CITY OF ALBUQUERQUE

**Re: Volcano Heights Drainage Compilation Report, Engineer's Stamp
Dated 12-12-2011 (C10/D000)**

Based upon the information provided in your submittal received 12-12-11, the above referenced report is approved based on the following comments:

ENLARGED VIEW
SCALE: 1" = 400'

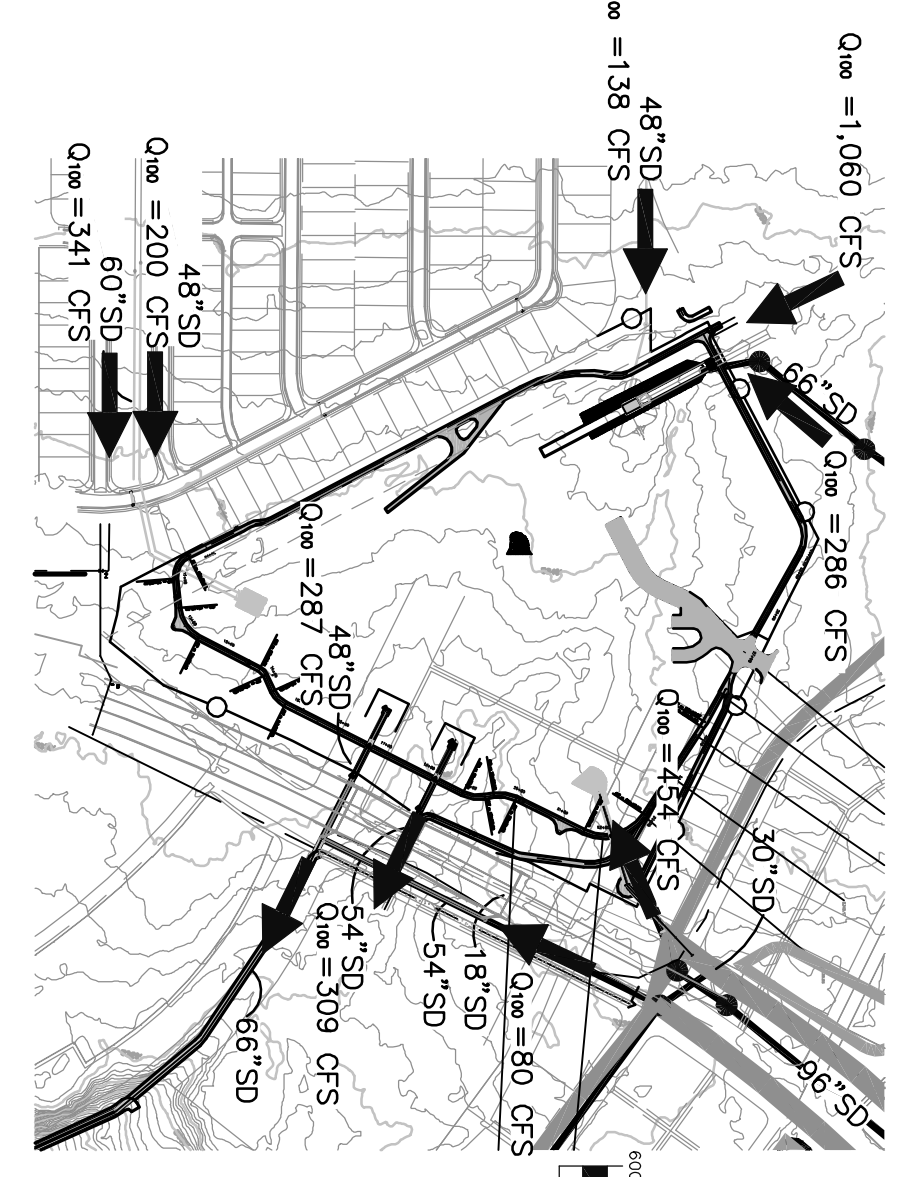
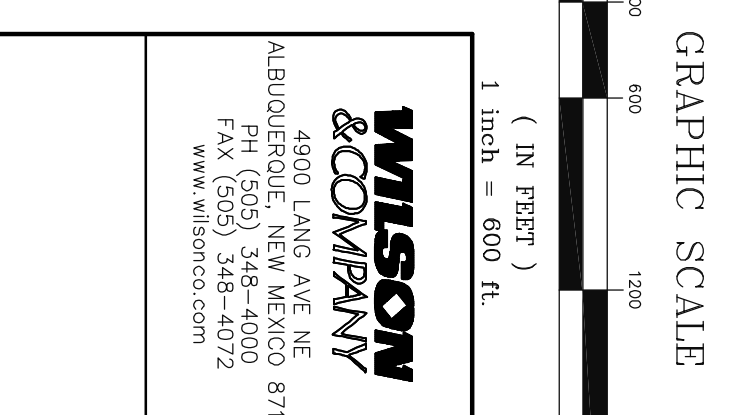
- The Trails may build a storm drain south on Universe Blvd. to the Boca Negra Dam.
- The Trails may be allowed a discharge in excess of 80 cfs.
